Thurgoona Community Action Group

10 September 2020

Re: Hume Battery Energy Storage System (SSD 10460) Environmental Impact Statement

Friends Glider comments on Hume BESS EIS

Figure 6-1 Predicted construction noise levels $L_{Aeq\ 15\ minute\ dB(A)}$, construction phase 1 (Civil works)

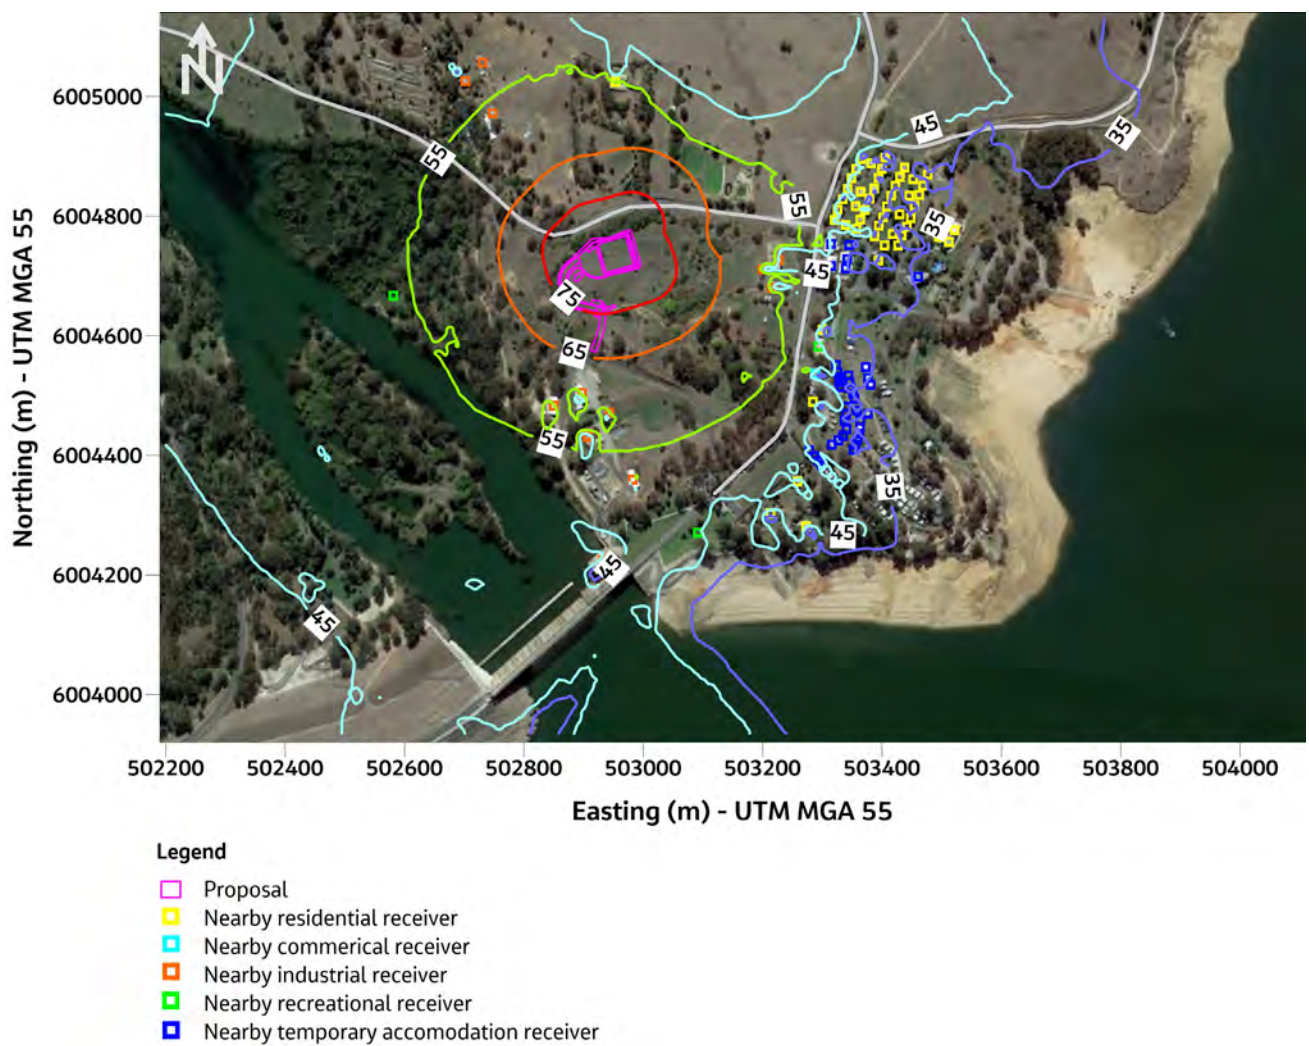
Noise and vibration maps presented for the construction stages of the proposed “Northern location” are presented in the Figures 6.1 to 6.3, Appendix H, pp 16-18 (attached). These were interpreted to obtain noise and vibration levels at the Trout Farm Road breeding areas during BESS construction.

- construction –Phase 1 (Civic works), 65 – 75 dB(A),
- construction –Phase 2 (Mechanical/structural), average 65 – 70 dB(A), and
- construction –Phase 3 (Electrical), average 55-60 dB(A).

Table 4.2 reveals the 55 dB(A) to 75 dB(A) interpreted figures for construction above, are 20-40 dB(A) above human acceptable values, **rated highly disruptive noise** (EIS, Table 12.2, p83).

FLHG is concerned the **highly disruptive noise** and vibration levels during the construction at the proposed Northern location will may **impact significantly on the glider’s day sleep cycle, and importantly, their ability raise and care for their young.**
